Preferred Project Report Construction of a Mixed Use Retail / Residential Building

Frasers Broadway
Block 2

Submitted to
Department of Planning
On Behalf of Frasers Broadway Pty Ltd

February 2010 ■ 09112

Revision

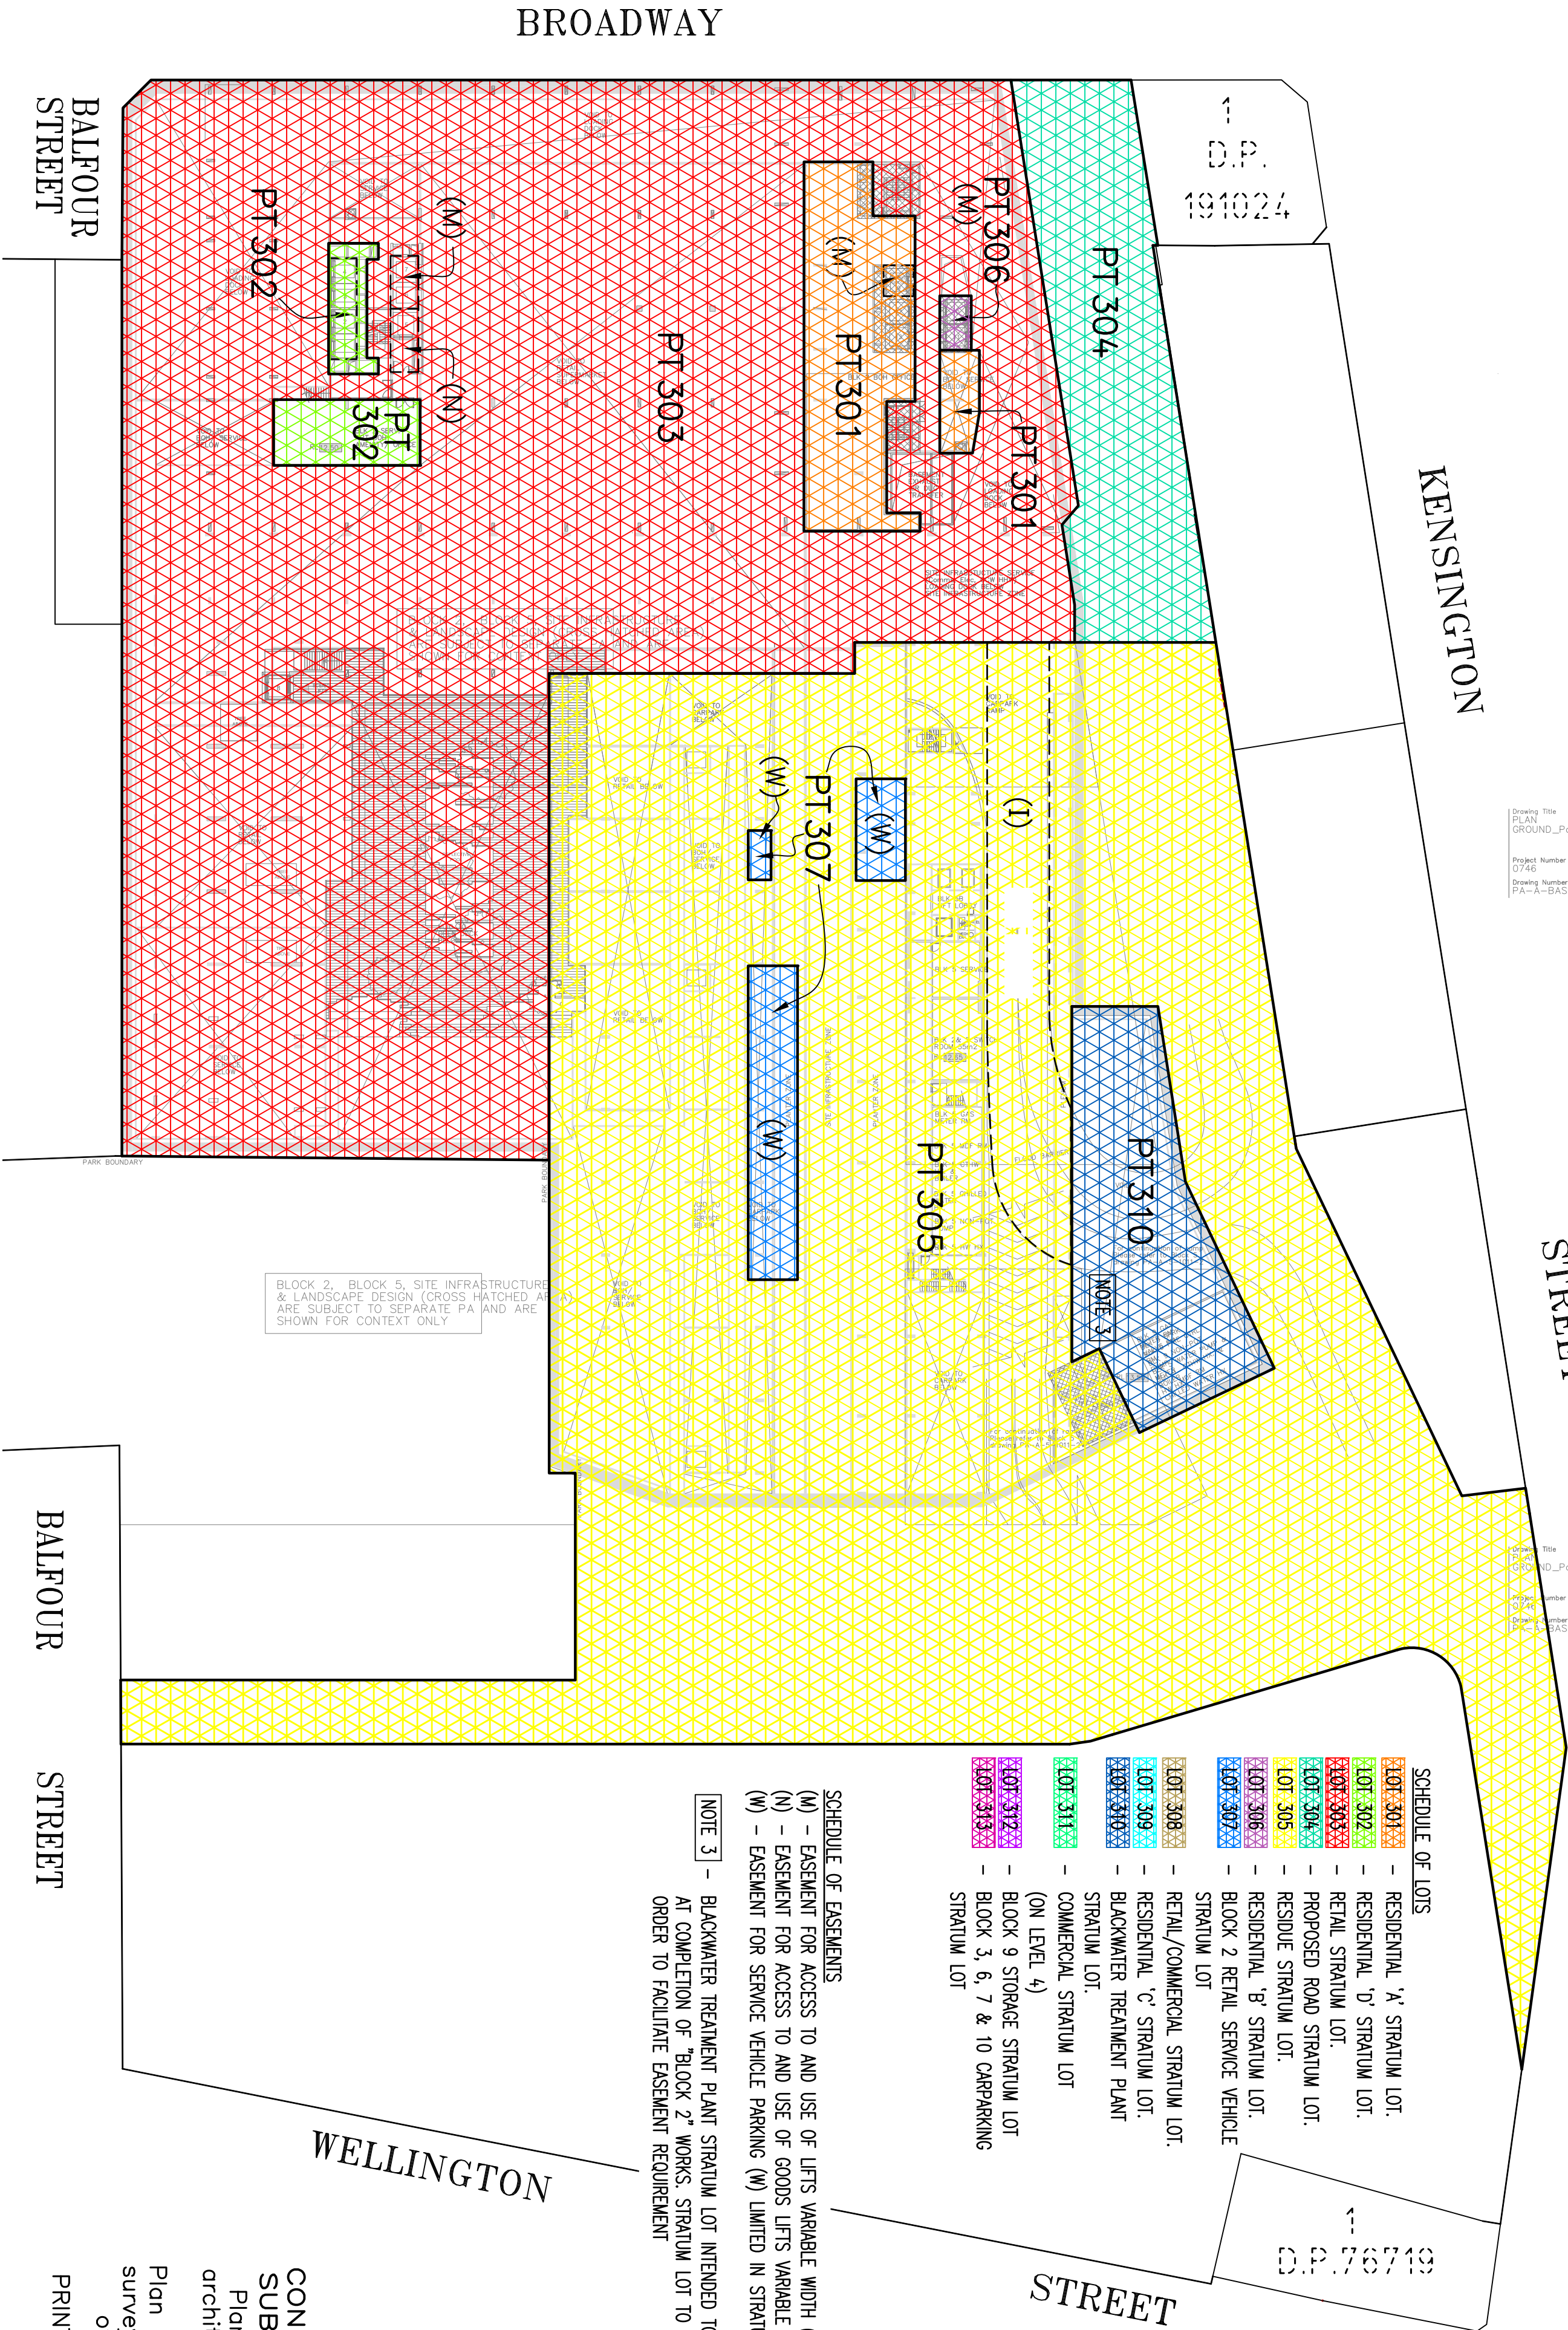
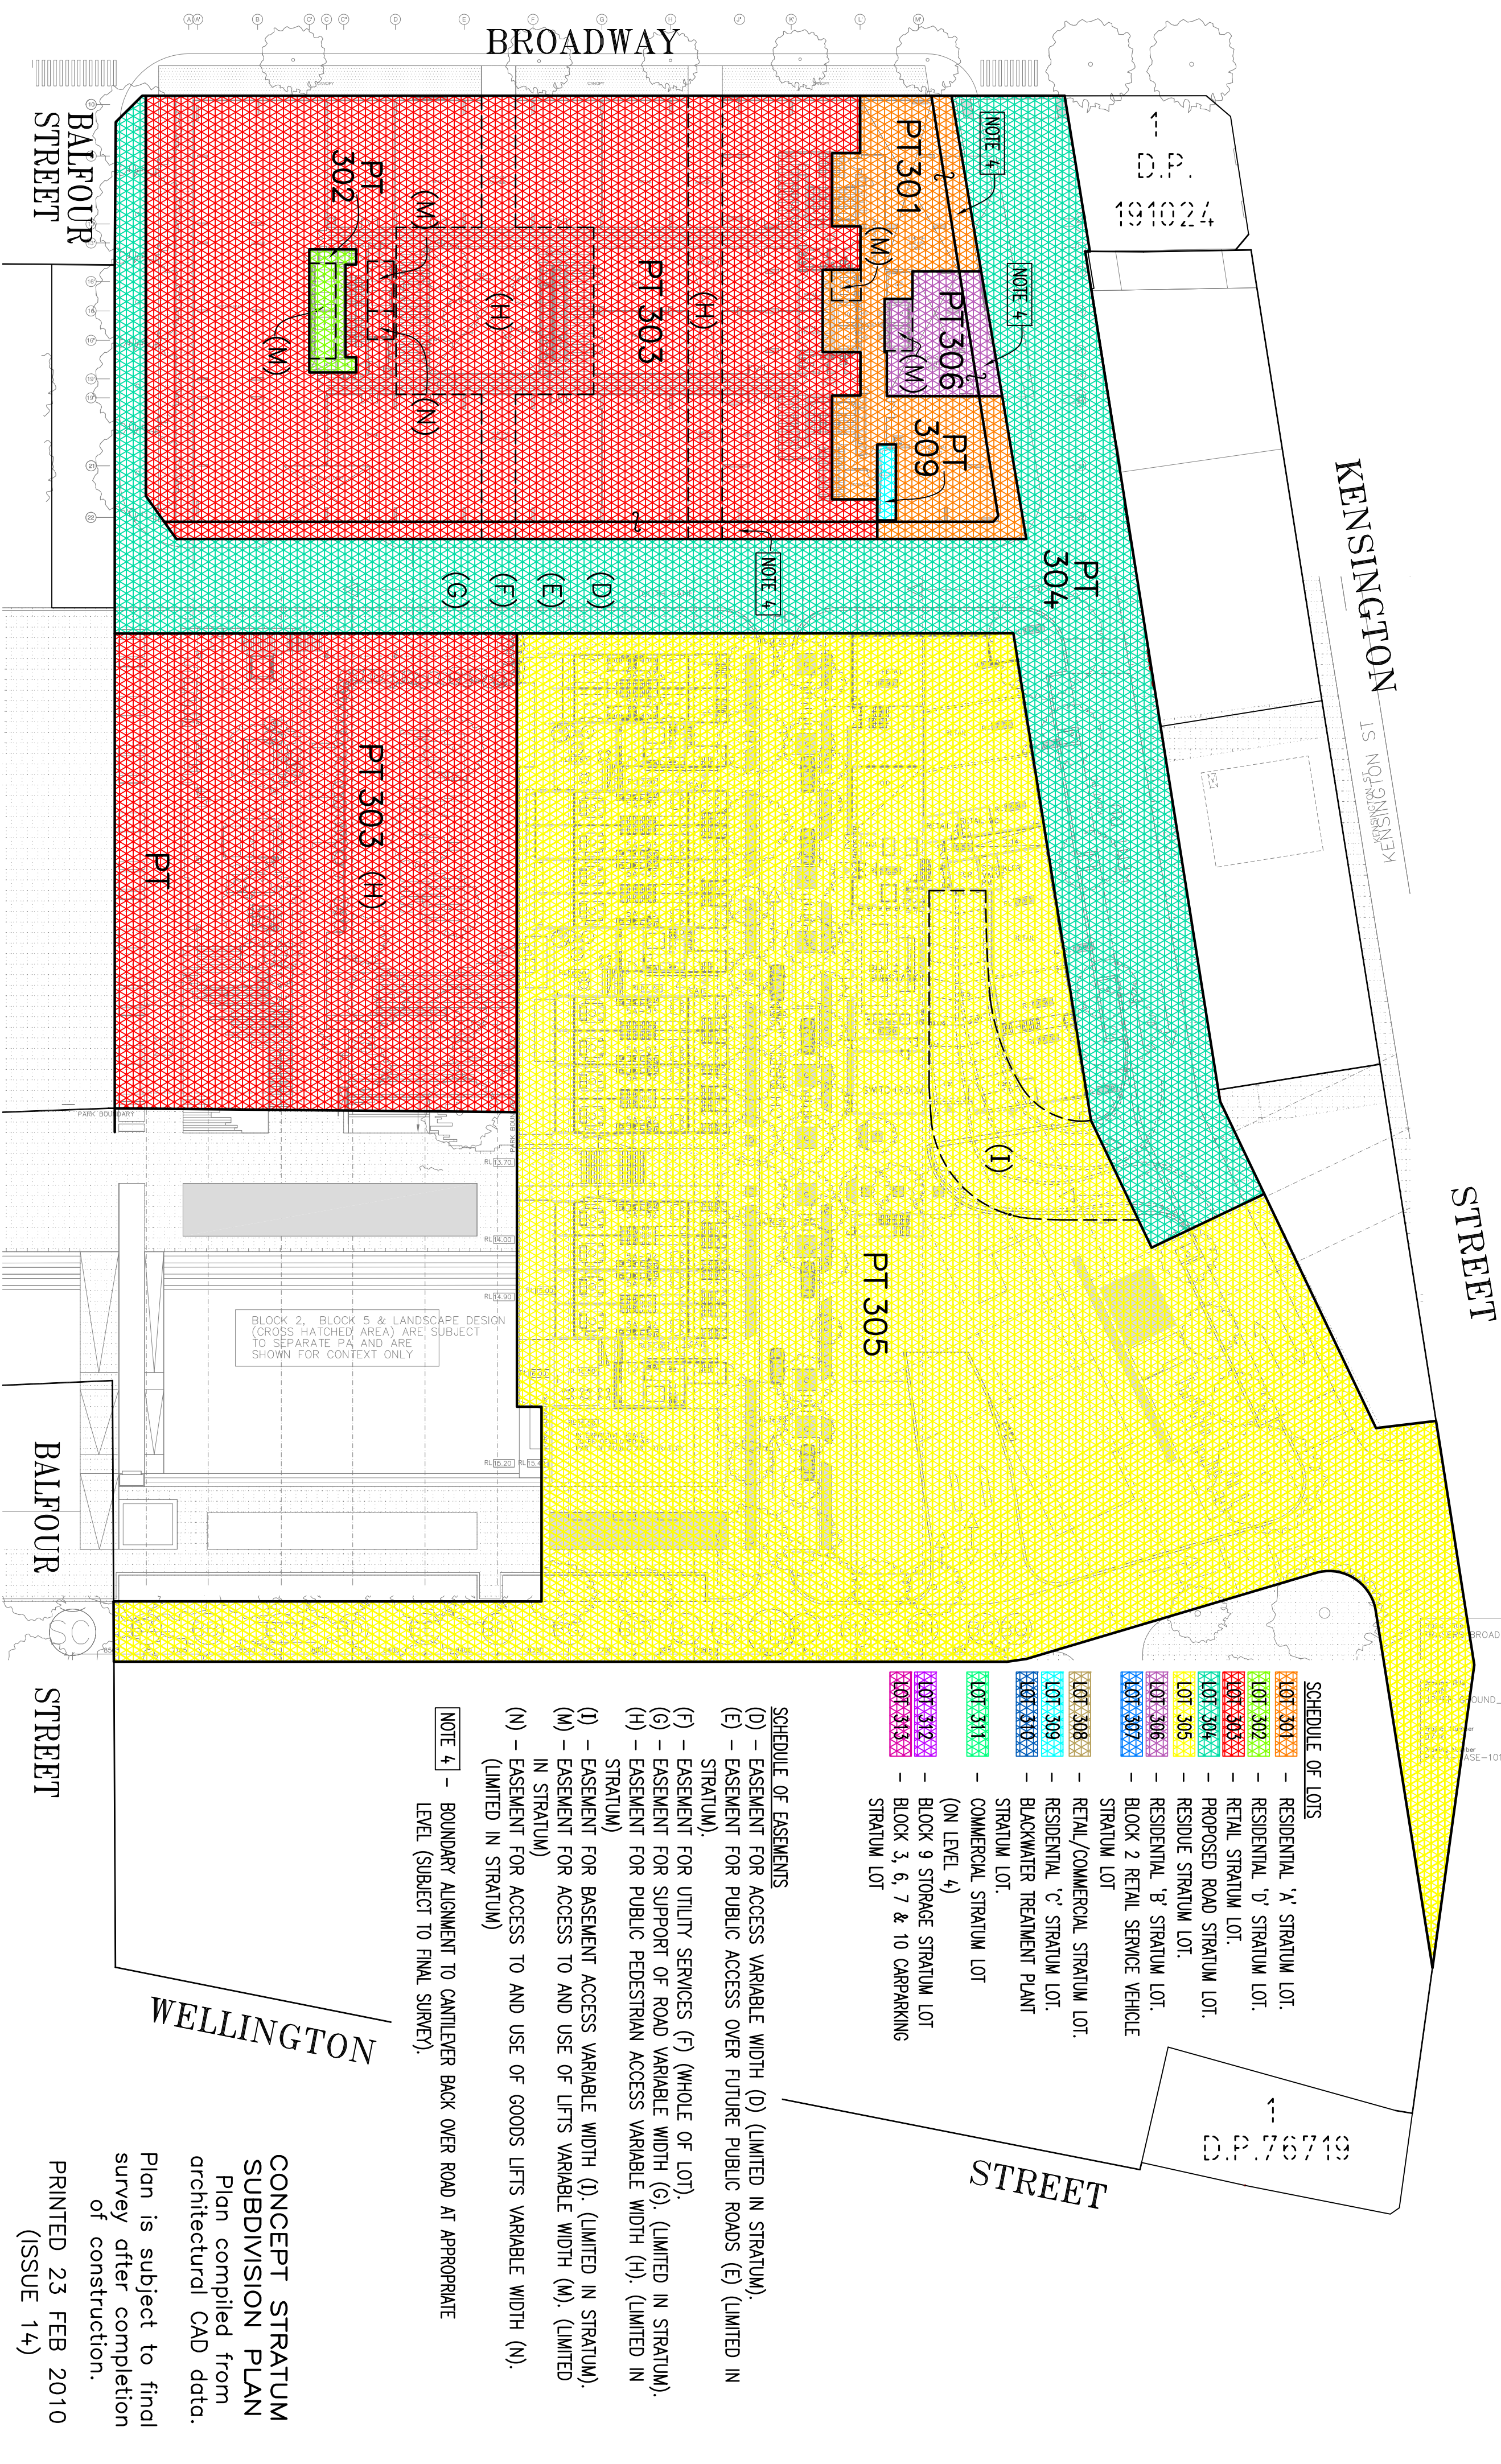
“Further additional details are to be provided in relation to the proposed stratum subdivision, including the ownership of the allotments within the subdivision and a detailed explanation of items contained within each allotment.”

“As the stratum subdivision relates to additional floor levels not provided within the EA, relevant plans are to be submitted for assessment to confirm that the proposed allotments have been correctly identified.”

“An additional set of plans is to be provided in colour and overlaid with the revised stratum subdivision plans taking into consideration details submitted for the basement project application.”

Revised Stratum Subdivision Plans, prepared by Denny Linker Pty Ltd are provided at **Appendix H** as requested.

The information on ownership is as follows:
